DEVELOPMENT REVIEW BOARD
SUPPLEMENTAL SUBMITTAL

PROJECT NO. PR-2021-005459
Application No. SD-2021-00163 SI-2021-01248

September 24, 2021

**RE: PR-2021-005459 RESPONSE TO DRB COMMENTS
LOT 1A BLOCK 2 & LOT 2-A-1 BLOCK 2 SUNPORT PARK
2900 TRANSPORT ST NE**

NOTE: ALL PARKING IS AT GRADE
NR-BP ZONING

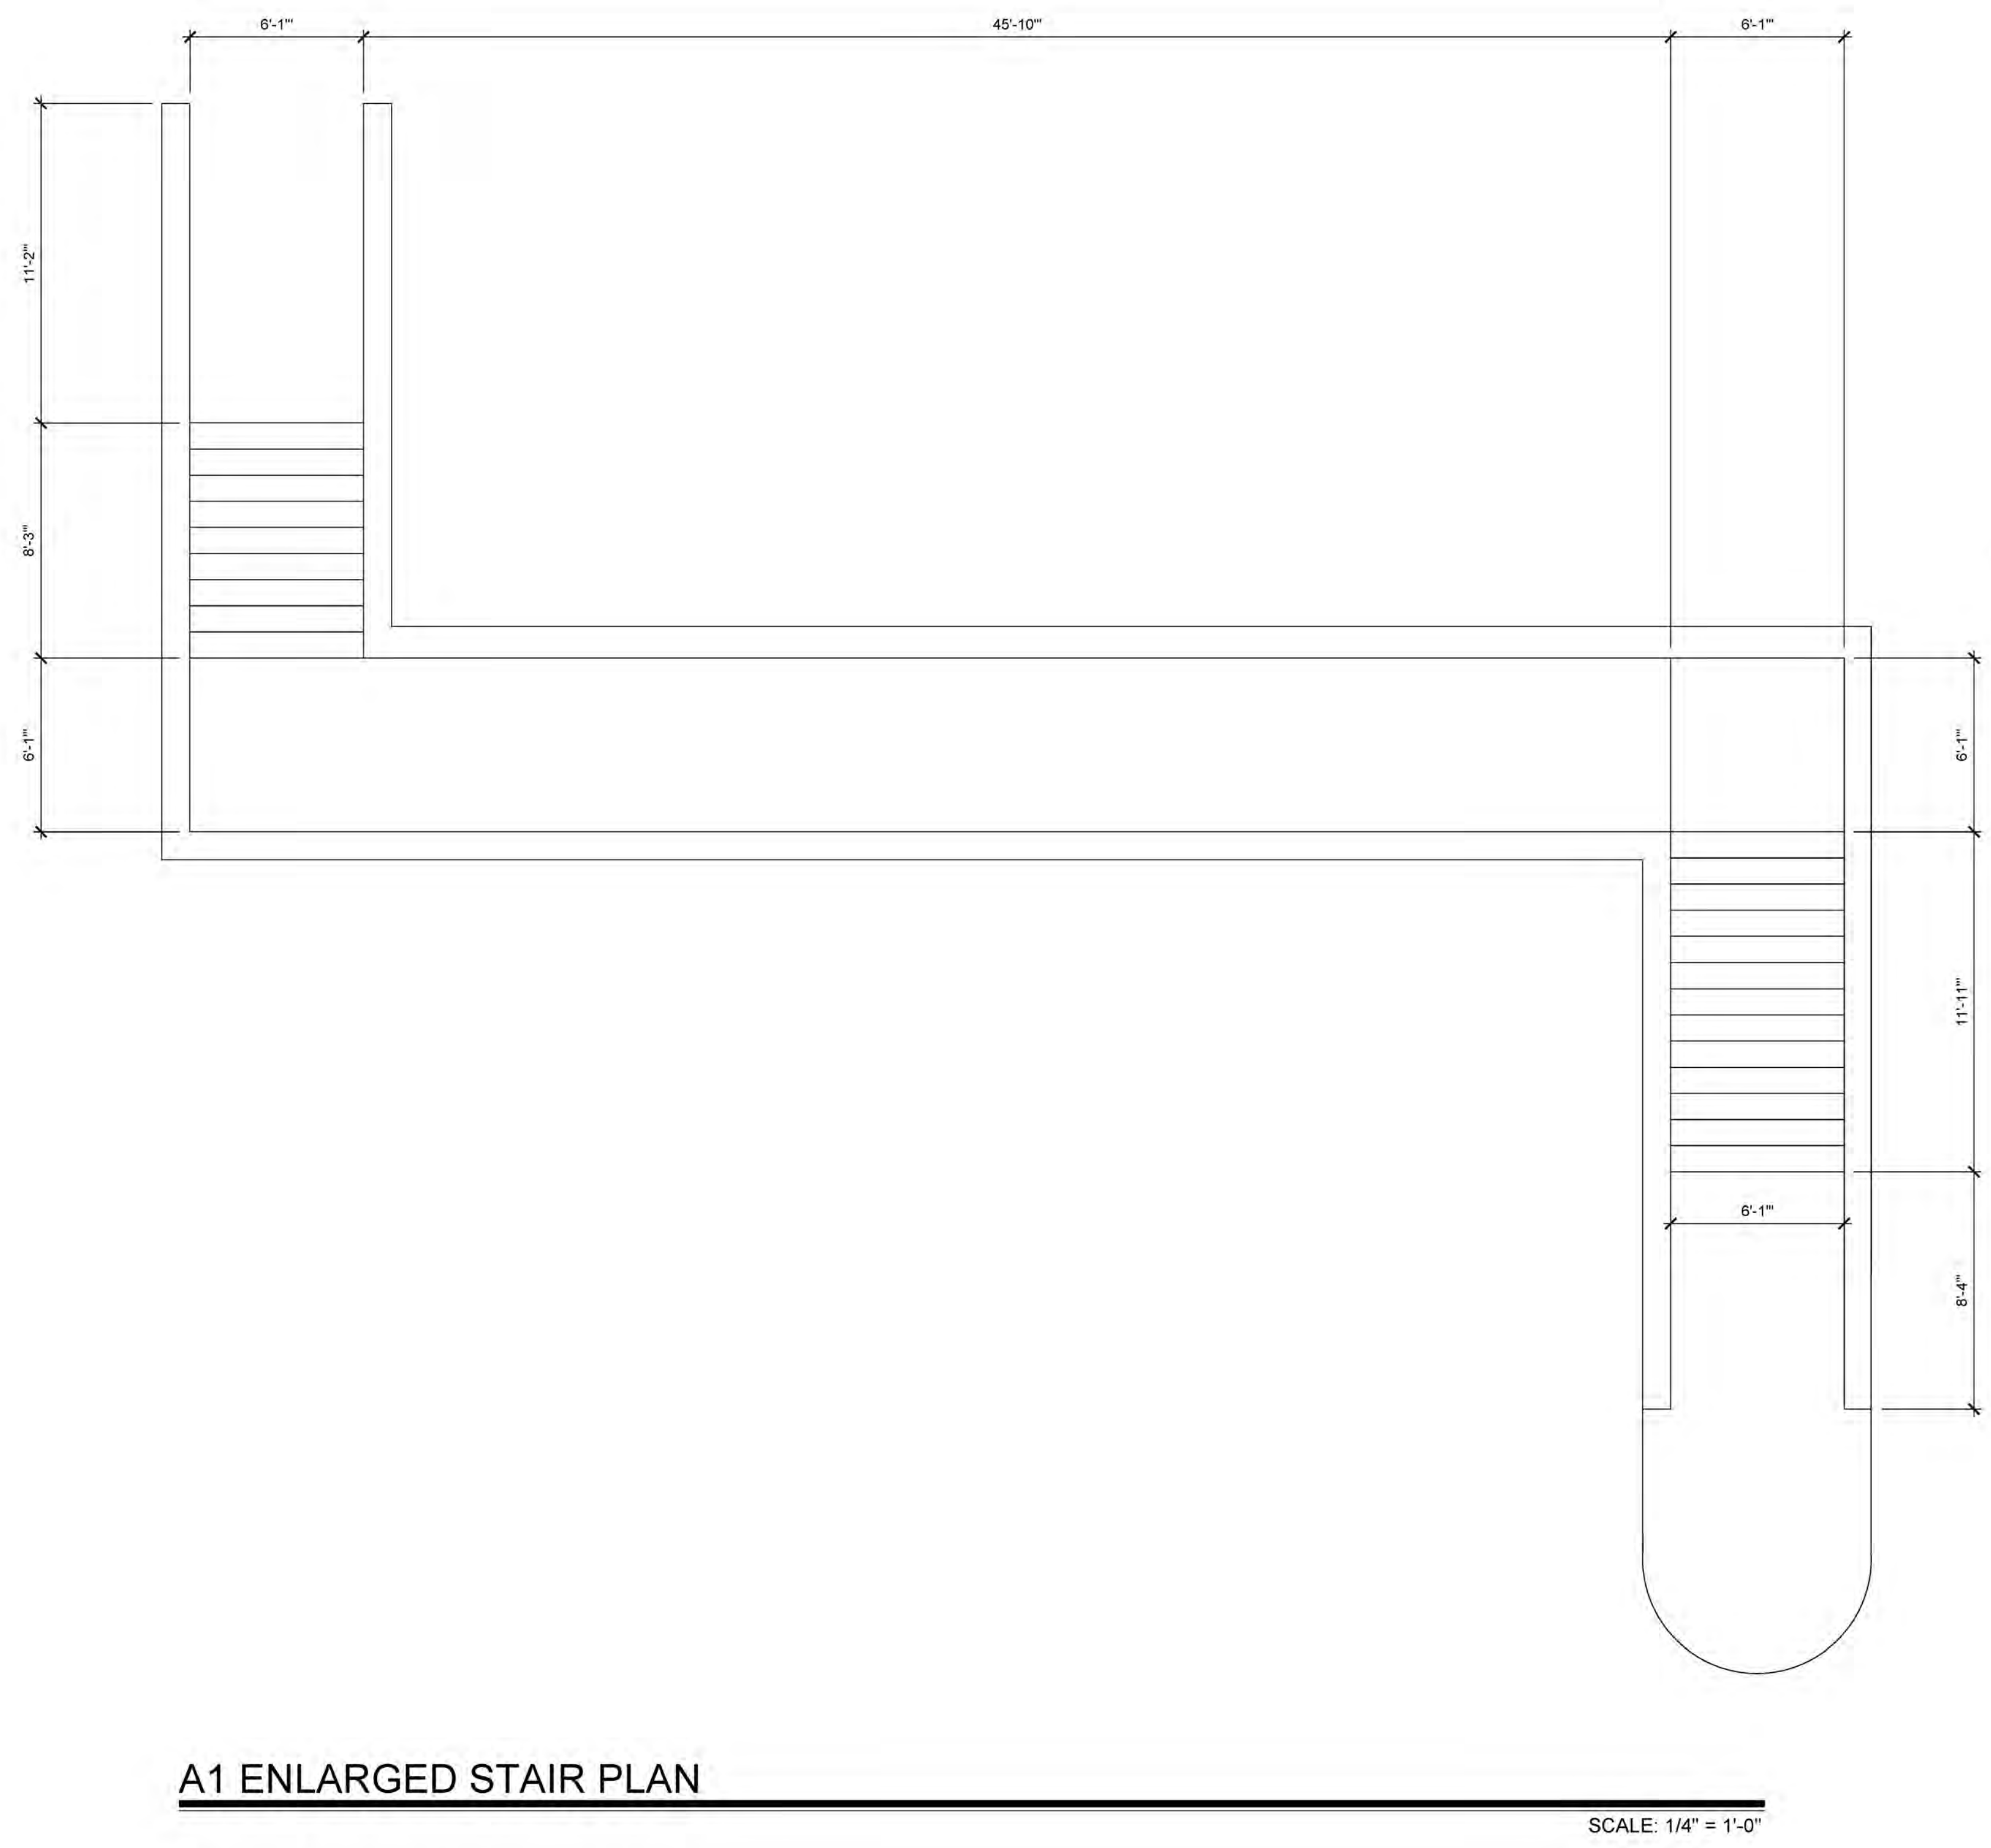
1. The amount of public sidewalk requires a work order. On the infrastructure list, show sidewalk and accessways. Add a note that work within public right-of-way requires a work order. On the site plan, indicate the landscape buffer width between curb and sidewalk.

2. Indicate typical dimensions for all parking stalls and parking aisles. Include dimensioning for the motorcycle parking spaces and van accessible aisles. (An overall 66-foot length is shown, but in one section along the west where the dimensions are shown, this does not add up to 66 feet)

3. Roadway Dimensioning for the east accessway is unclear.
RESPONSE: Additional dimensioning has been added.
4. Provide detail for the stairway to the western right-of-way.

RESPONSE: Revised detail has been added to the site plan.
6. Dimension all keyways. The minimum width is 5 feet.
RESPONSE: The keyway dimensions have been added to the site plan.

7. Provide a detail for on-site sidewalk along the parking spaces. Indicate if turn-down sidewalk edge will be built in these areas. Note that all sidewalks shall have a maximum slope of 2%.

5. The height of the fences/walls which are proposed to be constructed on the site need to be depicted on the Site Plan. Any fences/walls proposed need to meet the IDO requirements, including 5-7(D) pertaining to Maximum Wall Height.

RESPONSE: The infrastructure list includes the public sidewalk along the entire frontage as well as the accessways, ADA ramps, and "No Parking" signage. Landscape buffer note is added to the site plan.

RESPONSE: Typical dimensions have been added to the site plan. The 66-foot length in question was the width of one of the buildings and should be clarified now on the updated site plan.

RESPONSE: Reference Keyed Note K on the site plan.
8. Provide curb ramp details. Call out all ramps on the plan at the van accessible aisles, crosswalk aisles, etc. Make sure that the crosswalks line up with the sidewalks.

RESPONSE: The maximum height of retaining walls shown is 8 feet, these have been added to the site plan. Footnote 1 of Table 5-7-1 of the IDO states that wall heights in the NR-BP zone district shall be specified in the Master Development Plan. The SotoGrande approved site development plan (included in this resubmittal) states to follow the wall requirements in the old COA Zoning Code section 14-16-3-19. This zoning code section mentions that retaining wall height is not limited unless within five feet of public Right-of-Way, or if the height exceeds 8 feet abutting a residential zone, which neither of these cases apply. (Section 14-16-3-19(A)(3))

Seal: Landscape Architect
STATE OF NEW MEXICO
DANNY D. MITCHELL
239
REGISTERED
LANDSCAPE ARCHITECT
August 3, 2021
DRAWING NO: LS-101

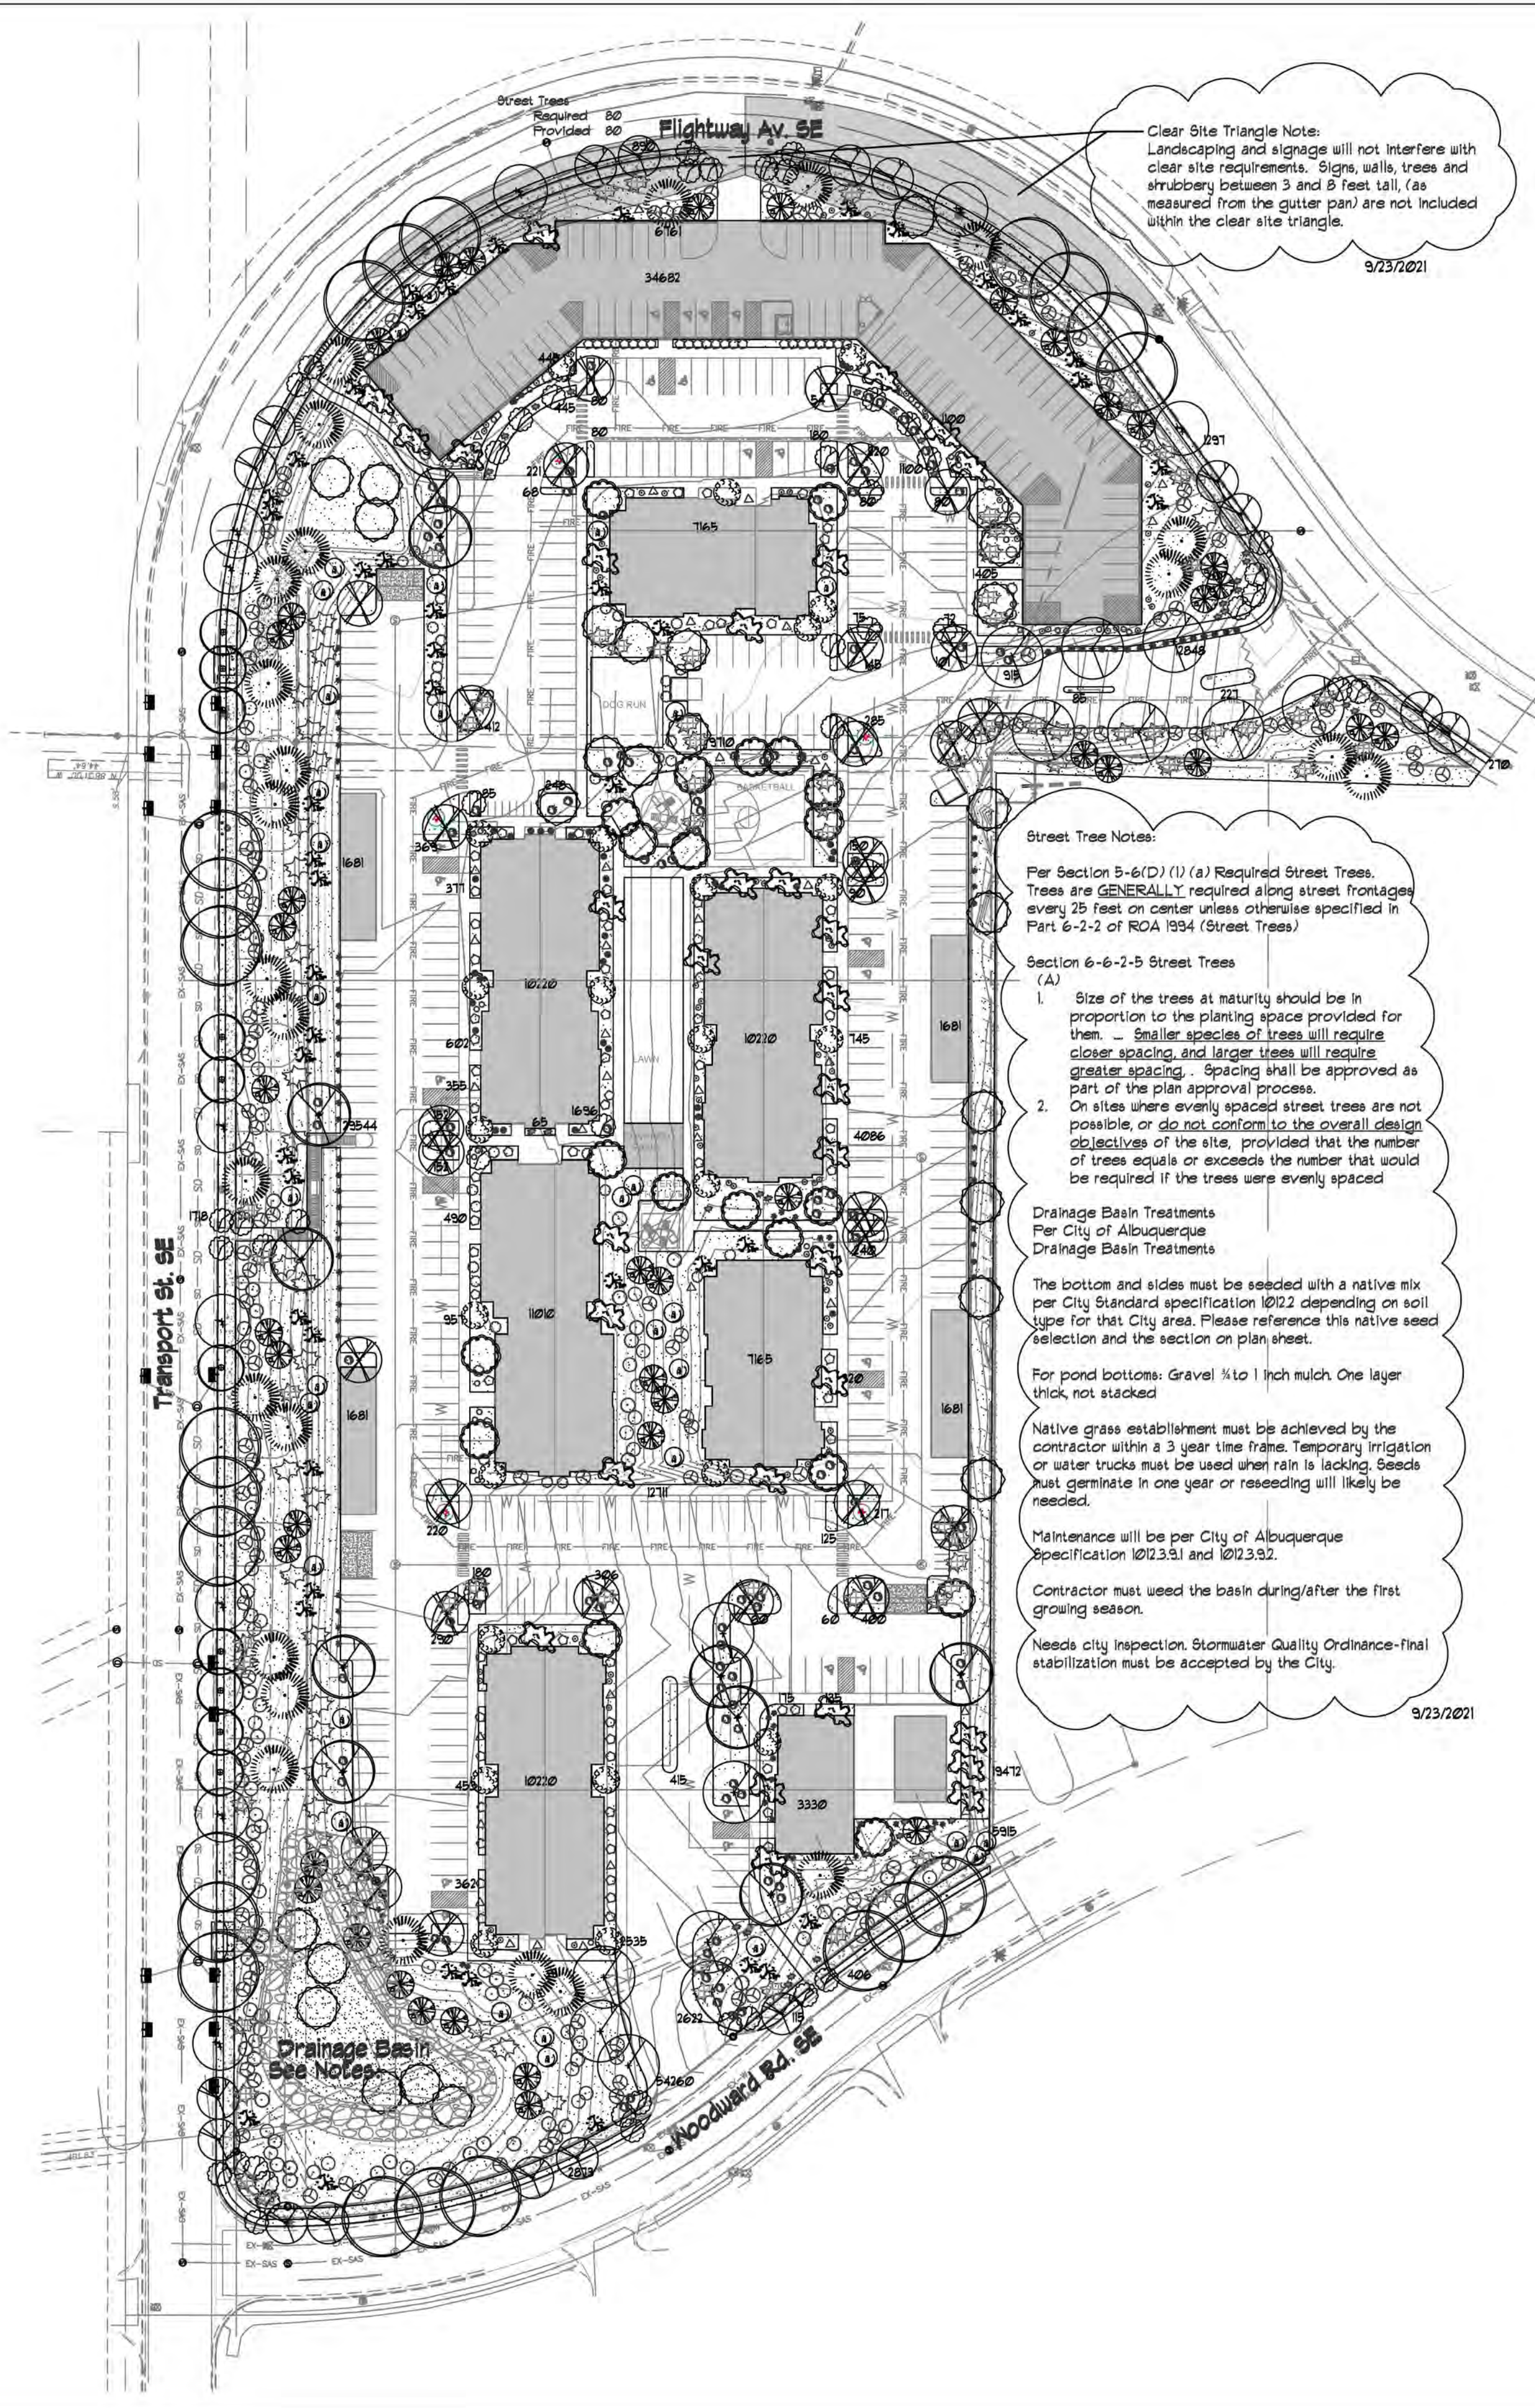
1. Pursuant to IDO 5-6(C)(4)(b), trees should be recommended by the Official Albuquerque Plant Palette (low water use, drought tolerant, or xeric species). Deborah Maple, Acer platanoides is not listed, and Greenspire Linden, Tilia cordata is Not Recommended.
RESPONSE: The trees species mentioned have changed to comply with the Plant Palette. See landscape plan included in this resubmittal package.
2. Will drainage ponds be seeded?
RESPONSE: Yes they will, per the Drainage Basin Treatment standard comments.

RESPONSE: Noted and applied. See latest landscape plan included in this resubmittal package.

RESPONSE: The landscape plans shows the evaluation of outdoor elements.
